DRB Application No.: 05DRB-01432 (SBP)

Project # 1004250

Project Name: MCBARK SUBDIVISION

TO: Sheran Matson, DRB Chair  
FROM: Stephanie Shumsky, Associate Planner  
SUBJECT: Project # 1004250/05EPC-00949/05DRB-01432

1 CONCEPTUAL SITE PLAN
NOT TO SCALE

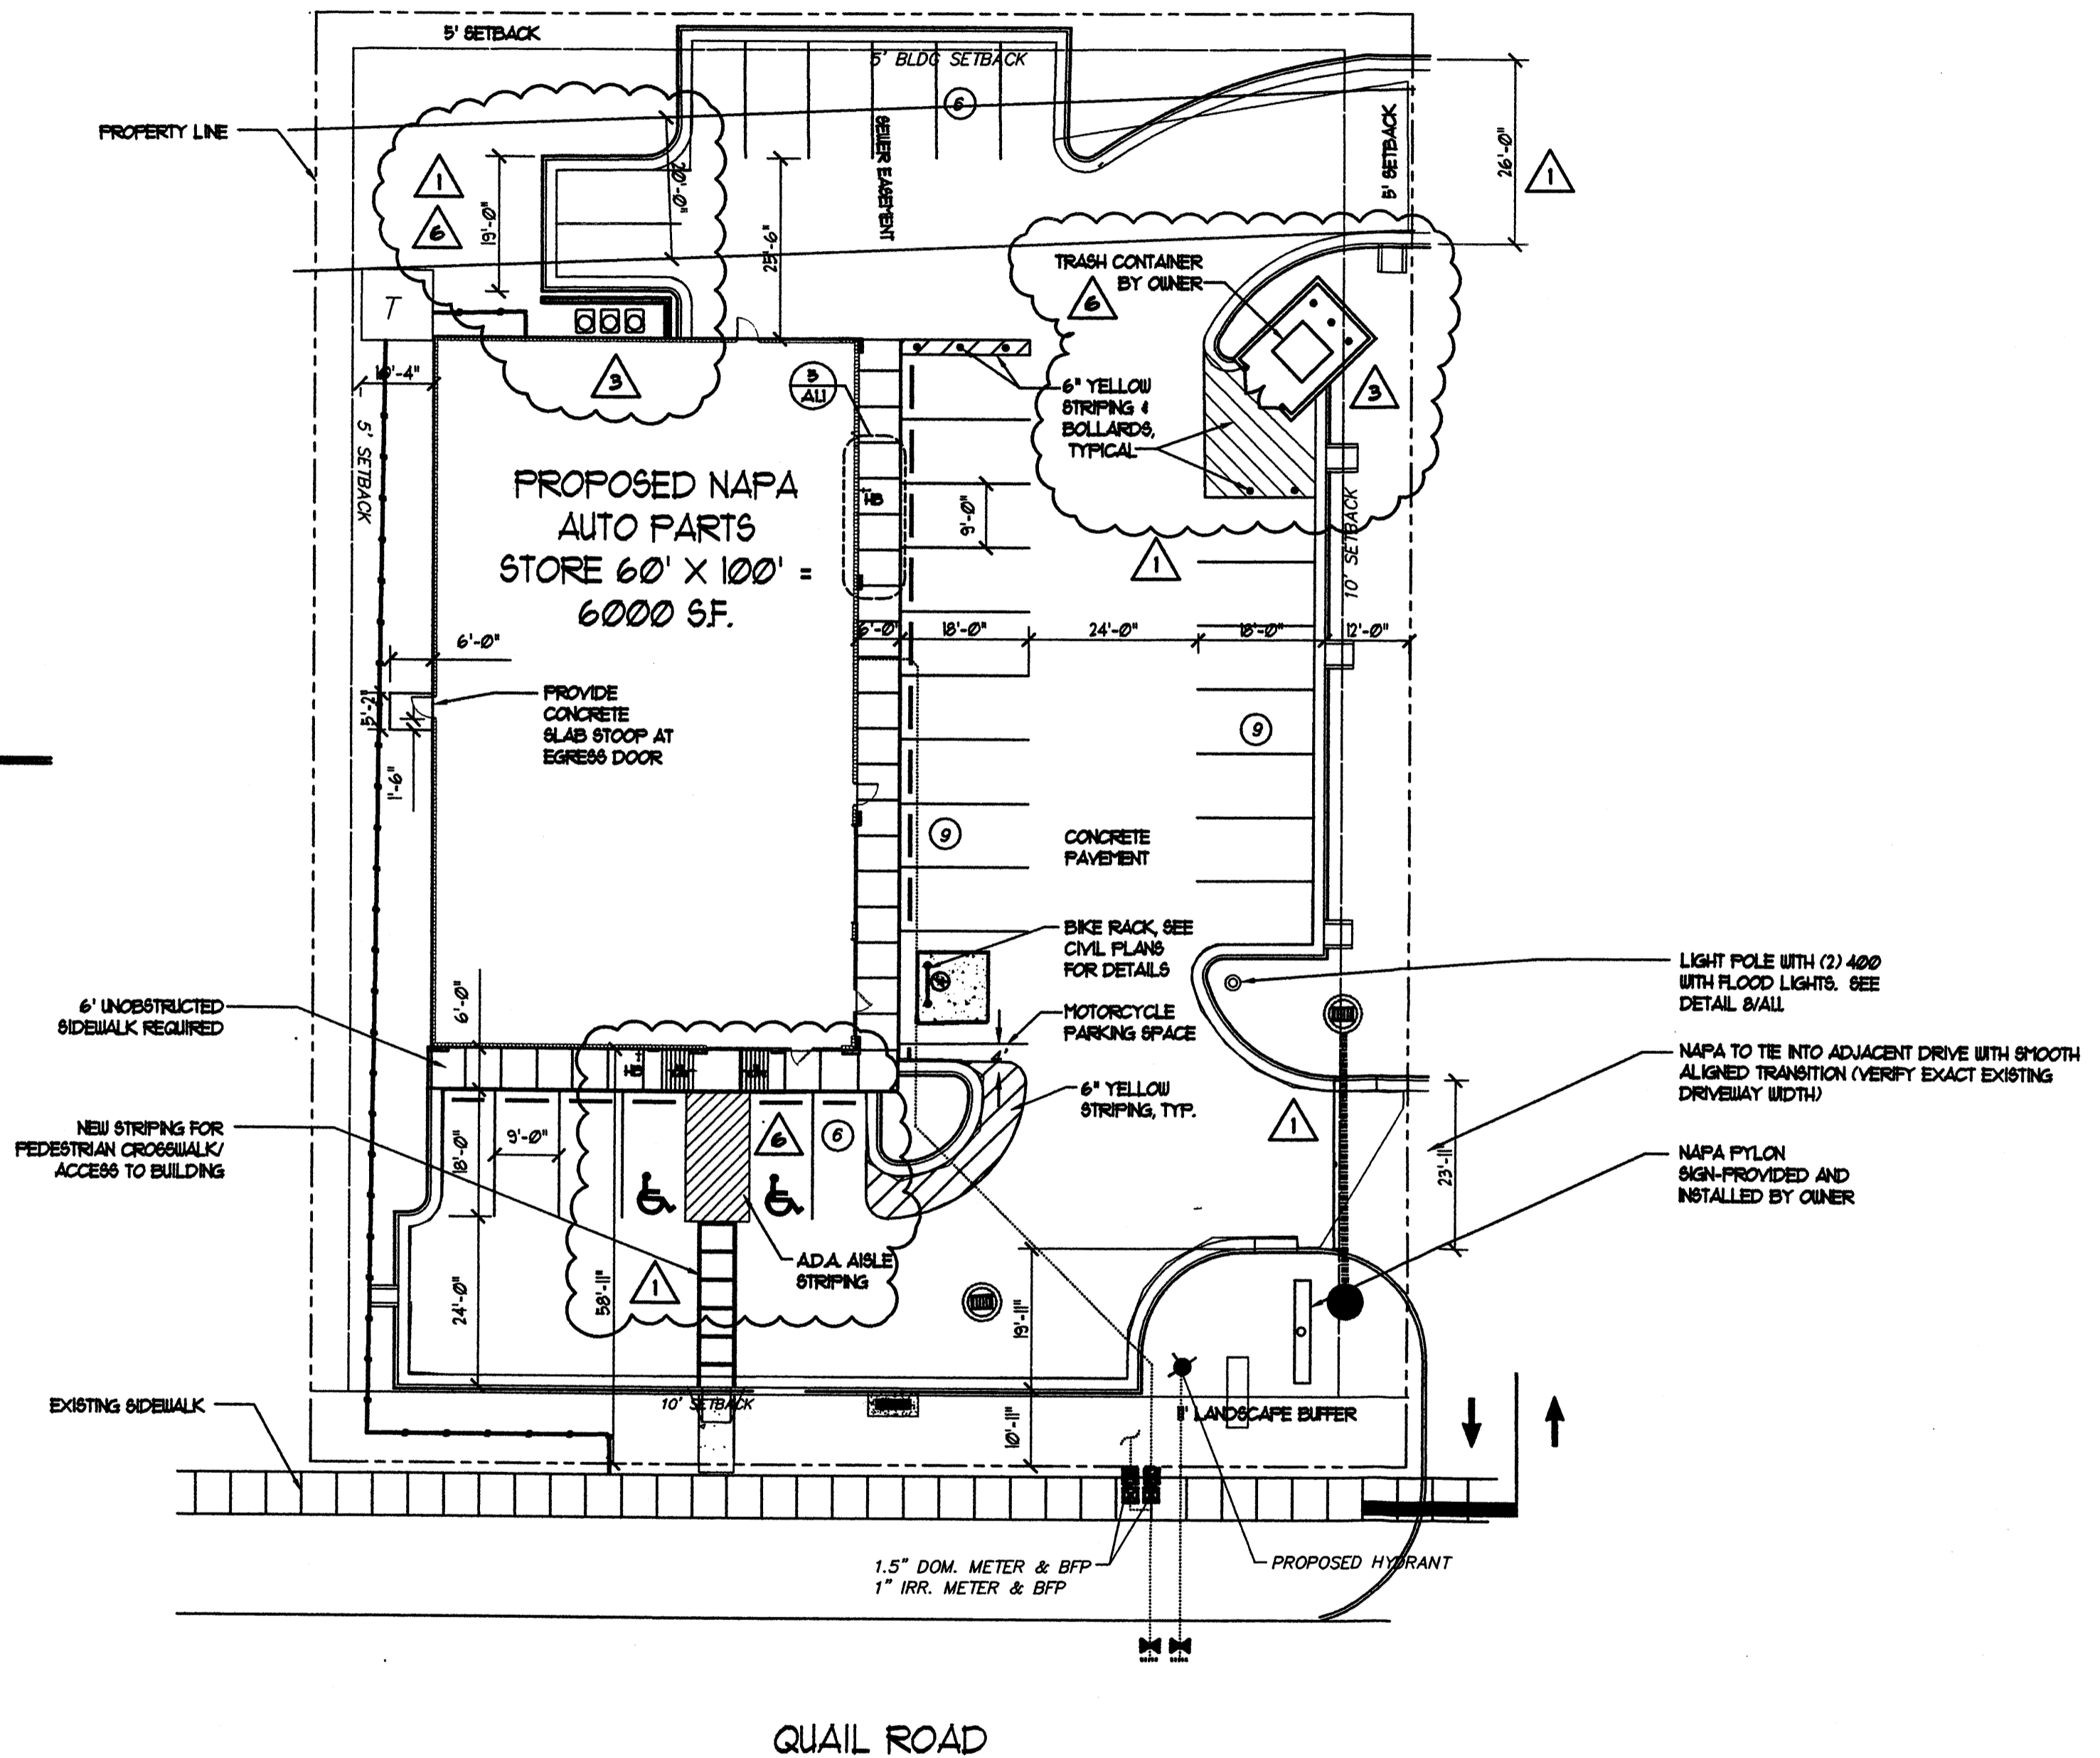
Note: Condition #10 requires the light poles to be 20' or less in height. The site plan depiction of the light poles complies with this condition. However, the letter from the applicant inaccurately states that the poles will be 26'.

SHEET TITLE
SITE PLAN
SCALE: 1" = 20'
DATE: OCT. 13, 2004
PROJECT: 04177.00

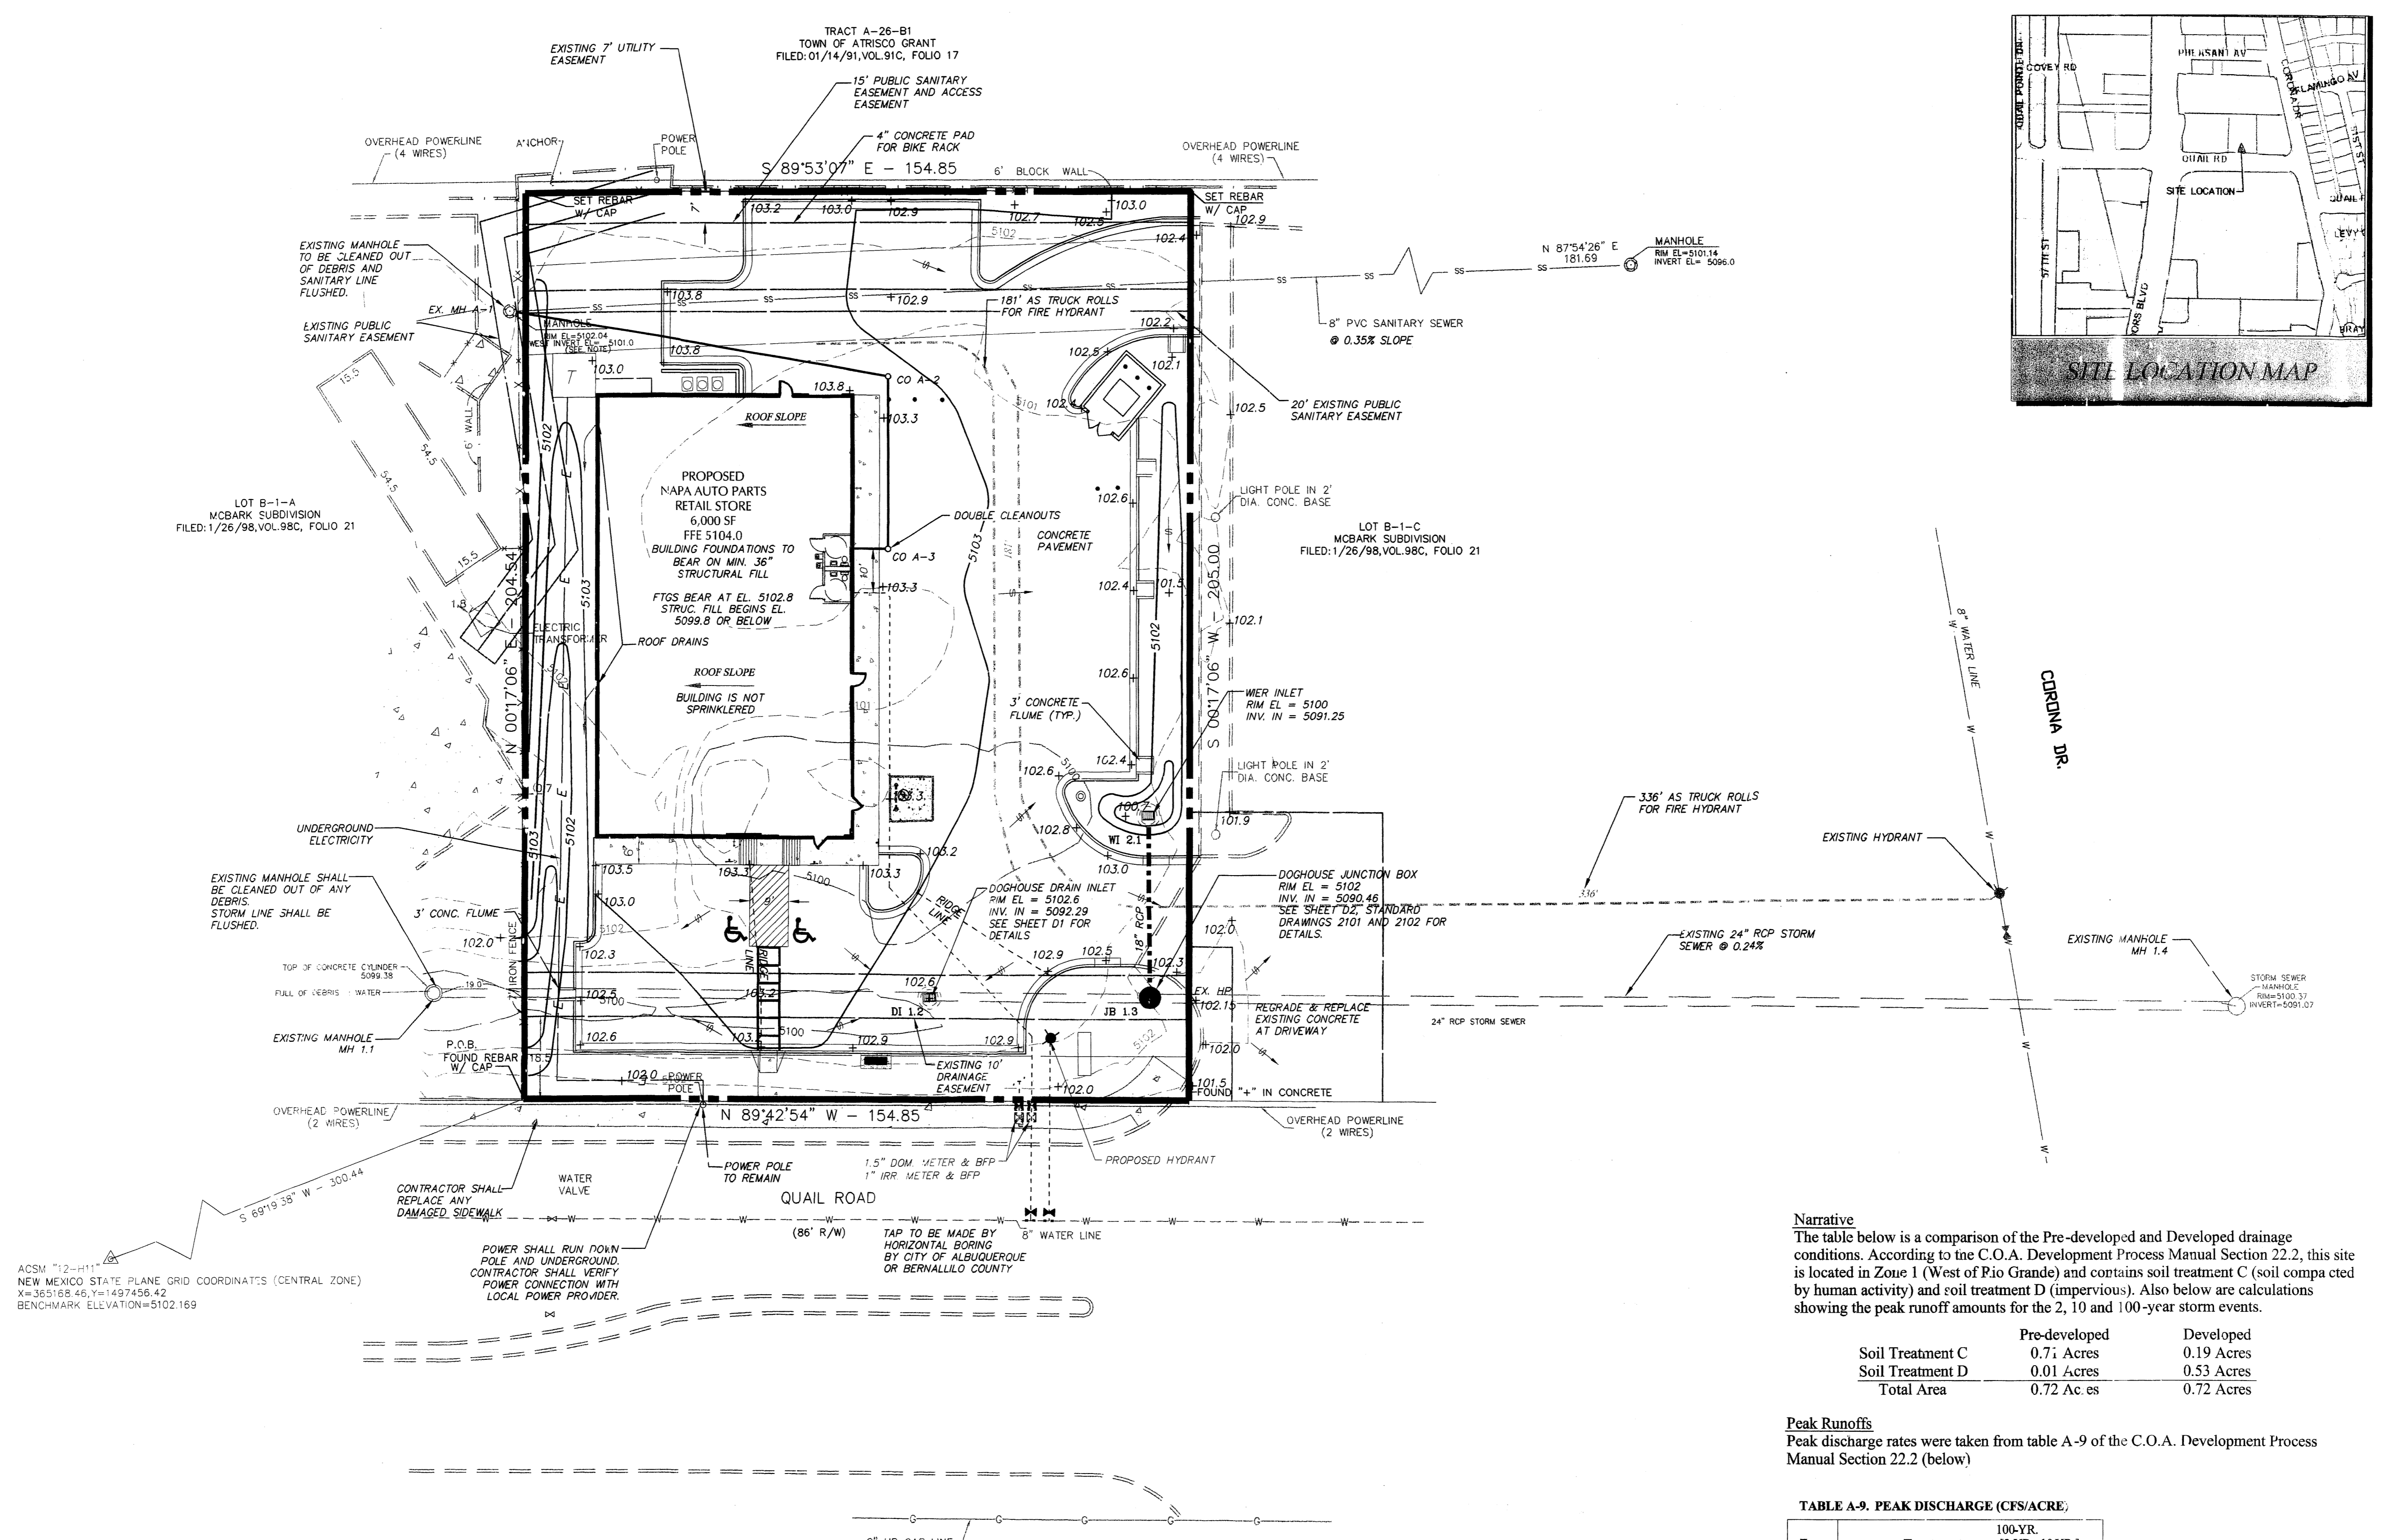
TRANSPORTATION: ADA RAMP  
 3 - COPIES of SITE PLAT  
 10' S.W. on 20' PARKING STRIPS w/ BUMPERS  
 OR  
 Bumpers

<u>No.</u>	<u>Comment</u>
1)	A 6' clear sidewalk is required at the building. Stall dimensions are 8.5x20'.
2)	Where is the cross access agreement for the north drive?
3)	What is the keyway dimension on the south side?
4)	Are the ADA ramps in place at the entrance drive from Quail? Are they located within public right-of-way or a pedestrian easement?
